From: Simon Power
Sent: 03 April 2009 14:40
To: Planning.Responses
Cc: Claire Rodway; Brian Holland
Subject: RE: Planning Consultation on: LU/73/09/

APPLICATION NO: LU/73/09/

Registered: 27-MAR-09
Site Address: Eden Park/Elysian Fields Worthing Road Toddington
 Littlehampton

Description of Works: Change of use of small area of Public Open Space land to temporary sales car park area to serve plots 393

**Proposed
Car Park Block
Plan**

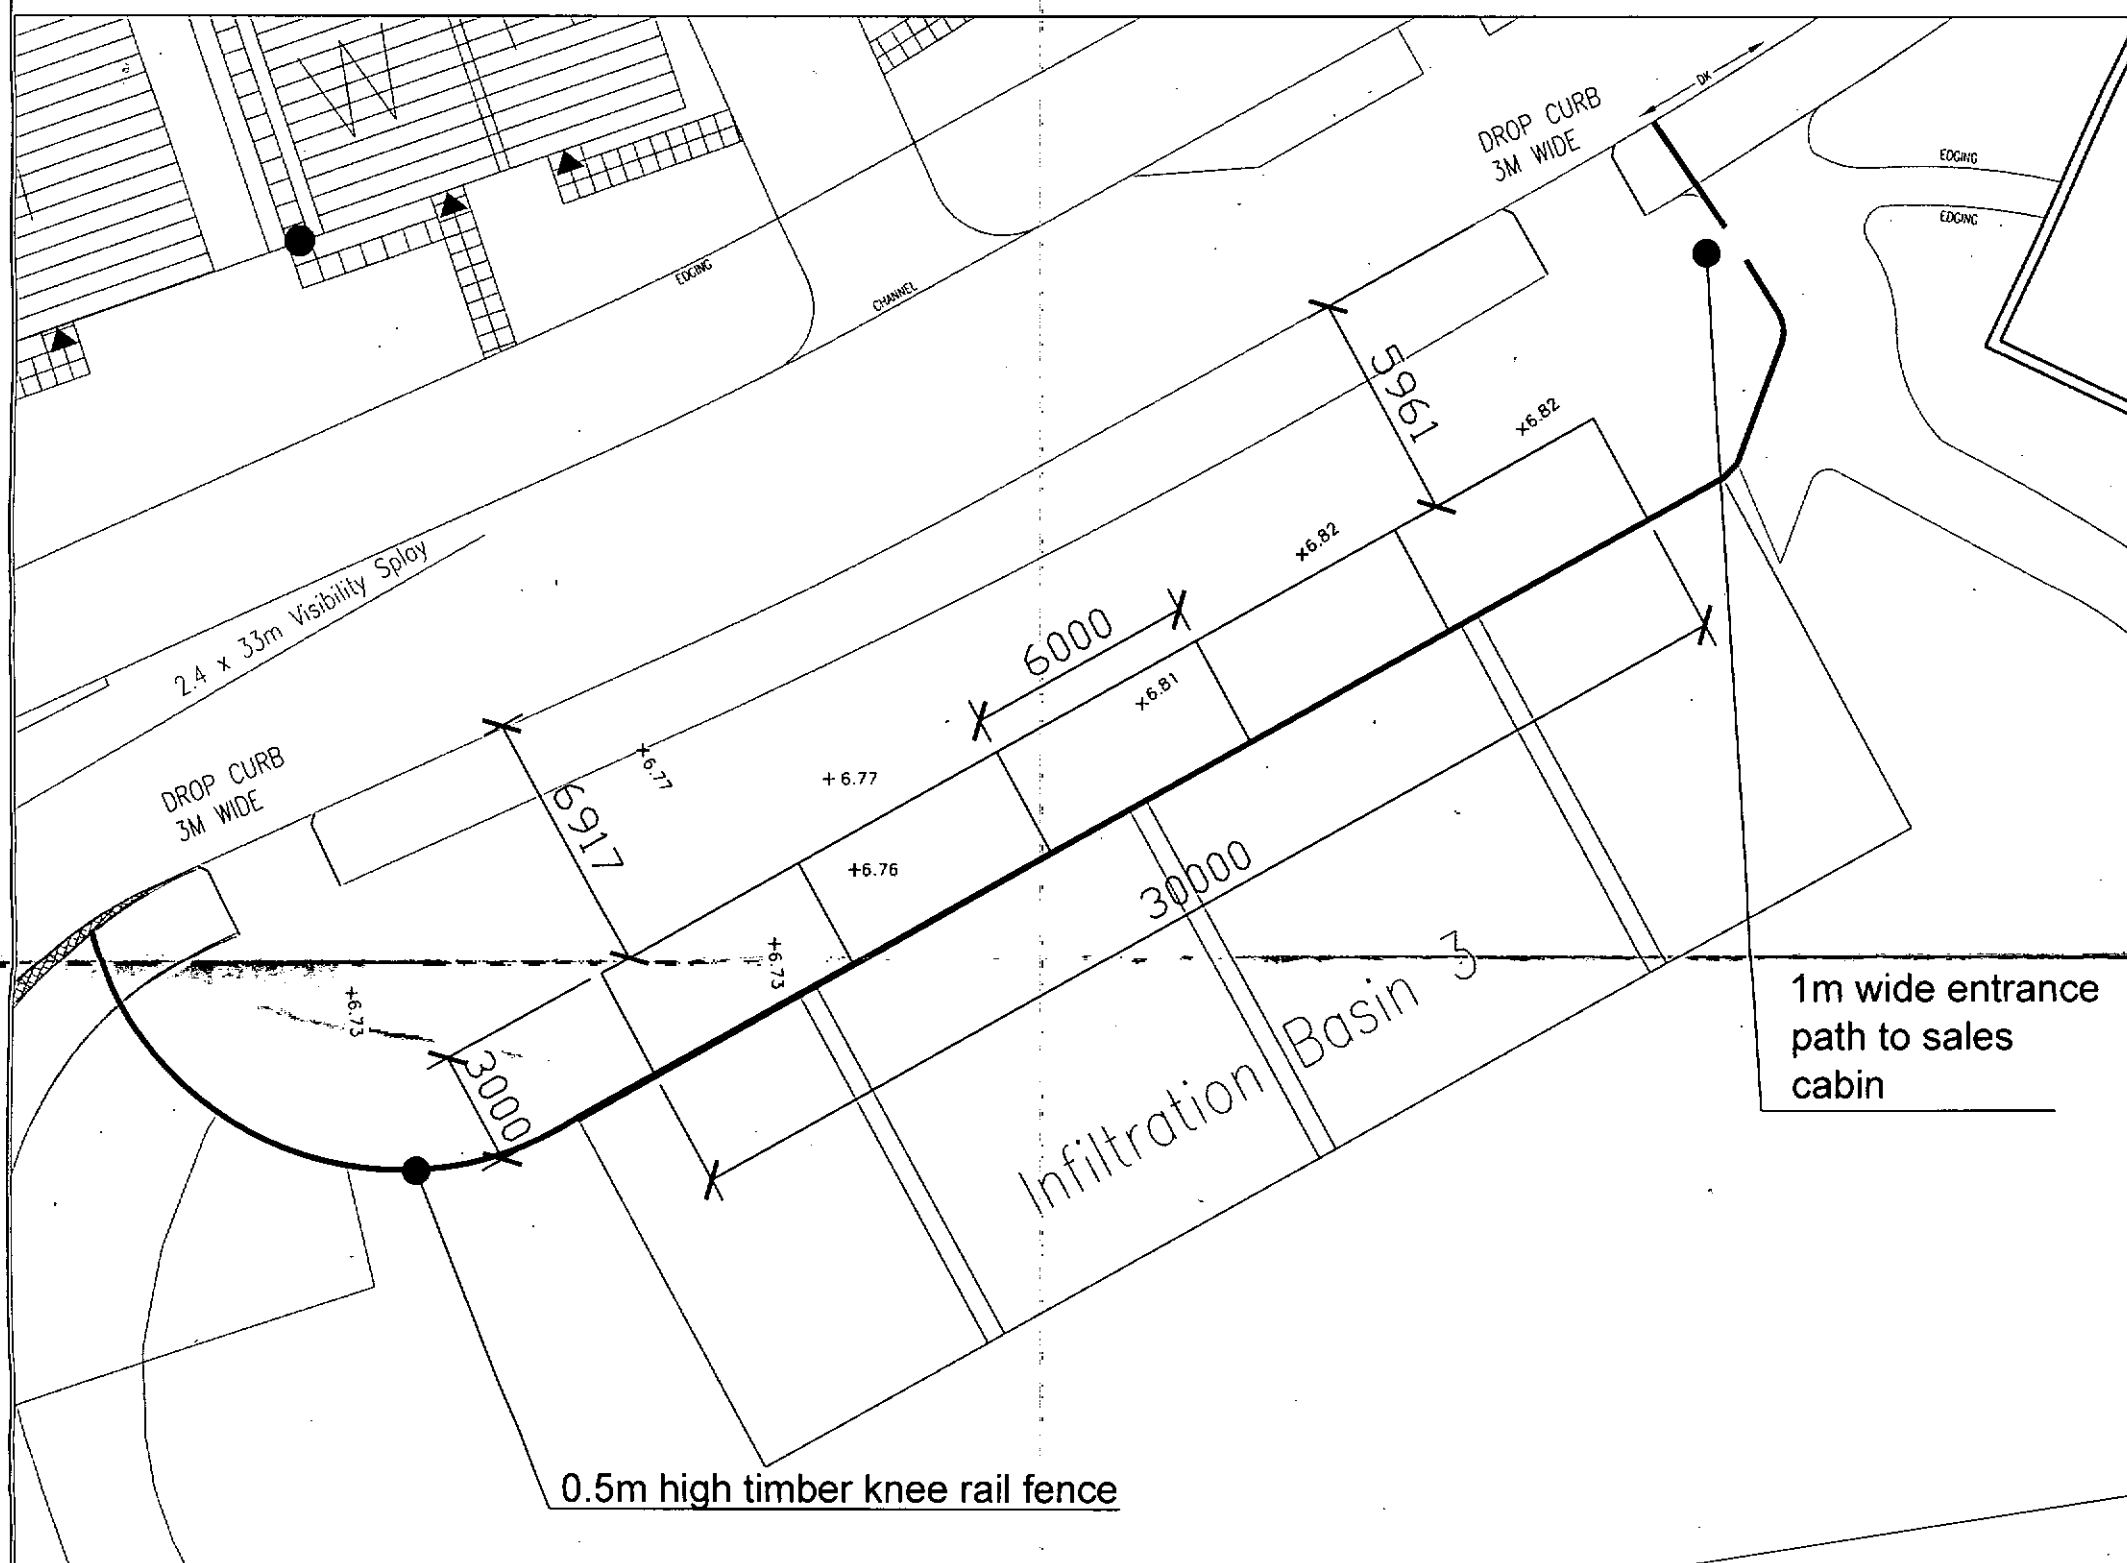
No direct connection is to be made to Infiltration Basin 3. If any drainage connection is proposed to the existing surface water system, a detailed drawing is to be submitted for approval. The integrity of the existing drainage basin is to be maintain, and care taken that no damage is caused.
